Consultation Response from KC, Lead Local Flood Authority		
2020/90441 Pennine Service Station, Bradley Road, Bradley, Huddersfield, HD2 1QD		
Discharge conditons 3, 6, 7, 18 on previous permission 2019/92233 for erection of petrol filling station, including new shop building, canopy, jet-wash and below ground storage tanks		
Date Responded: 31 March 2020	Responding Officer: Aleksandra Tomczyk	Responding Ref: 0
<u>Summary</u> Kirklees LLFA OBJECT to discharge of conditions 3 and 7 and require FURTHER INFORMATION to be provided on the design of surface water discharge system. Kirklees LLFA have no objection in principle, to discharge of condition 18. However, this condition cannot be recommended to be discharged before conditions 3 and 7 are fulfilled as well. Kirklees Flood Management and Drainage, as the Lead Local Flood Authority (LLFA), reviewed the Decision Notice for application number 2019/92233 and make contribution to the following conditions: Condition 3 Notwithstanding the submitted plans, development shall not commence until a scheme detailing foul, surface water and land drainage, (including off site works, outfalls, balancing works, plans and longitudinal sections, hyd

Attachment D – Drainage Drawings

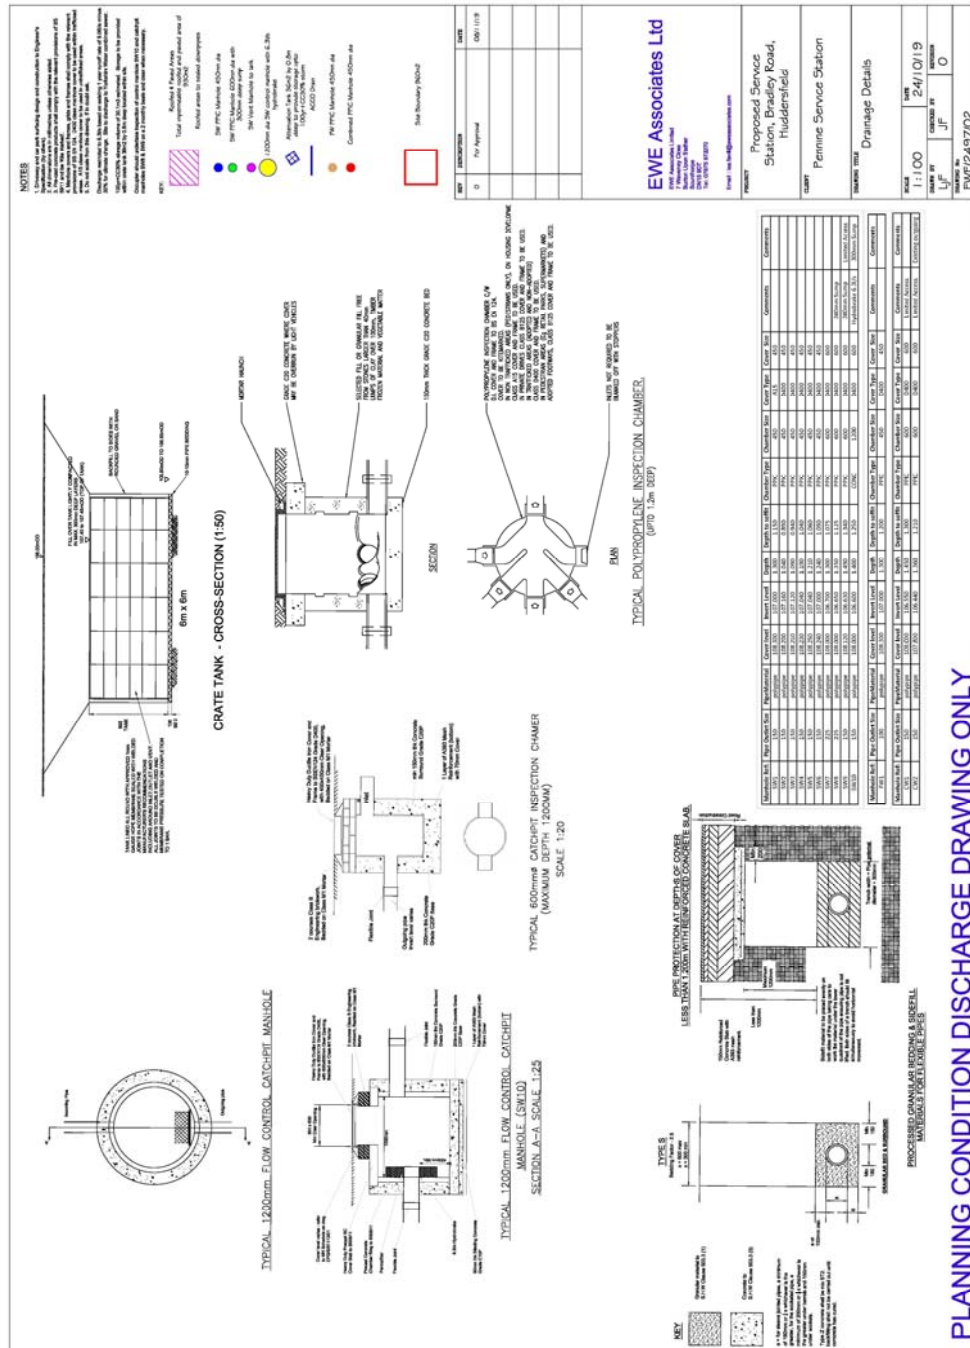
- **Kirklees LLFA are object and require further information** on storage provision. The technical note states that 30.1m³ of surface water storage will be needed for the 1 in 100 +30%cc scenario. The applicant proposes to provide 36m² x 0.8m deep crate tank to facilitate that which would provide 28.8m³ of storage which is significantly less than is required. Furthermore, taking into account that crate systems typically have a void ratio of between 92% and 95%, the proposed sized tank would provide from 26.50m³ to 27.36 m³ of storage respectively. From the applicants own calculations this would be insufficient, however it may be that this additional volume is available in the pipe network, however no evidence is available to show this.

The applicant should review this proposal and provide updated information.

DRAWING NO
EWE/2497/01

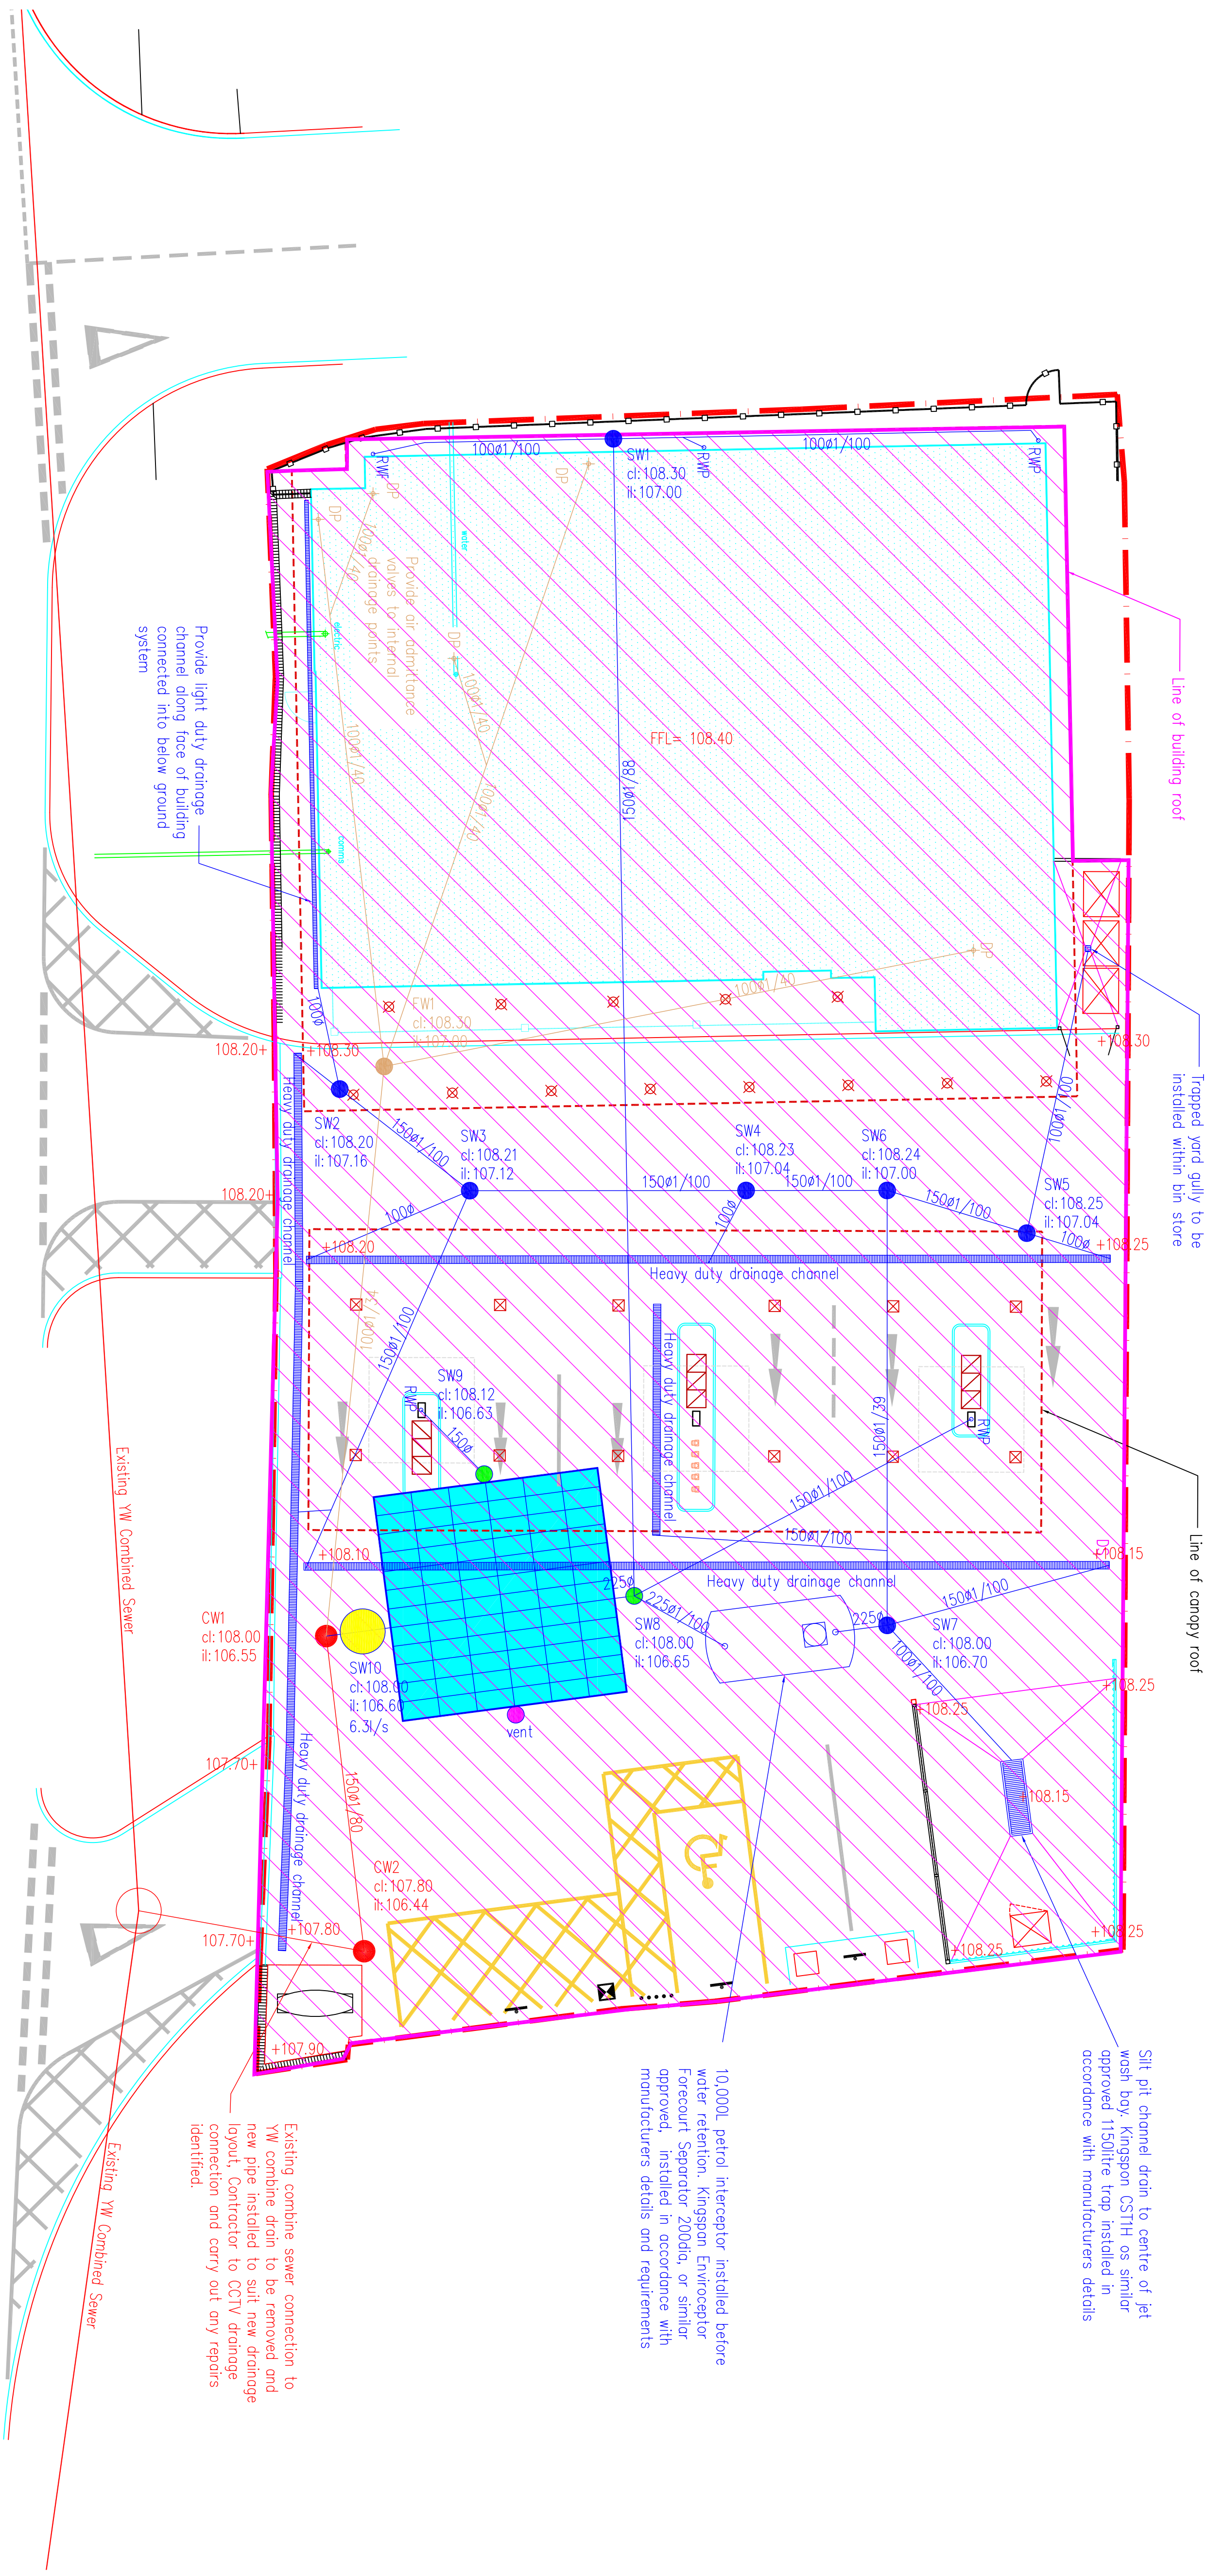
- Details of the 'light duty' and 'heavy duty' channels should be included in the drawing. This should include the type, levels, sizing and length;
- There should be manhole chambers placed in locations where the lateral drains are connected to the piped system;
- Water from the jet wash bay should not be connected to the surface and rain water system, as it is not classed as rain water and could result in siltation. A separate connection is required or a connection downstream of a Surface water flow control. The applicant should consult with Yorkshire Water as the jetwash may require a flow control and similar storage.

The applicant should review this proposal and provide updated information.
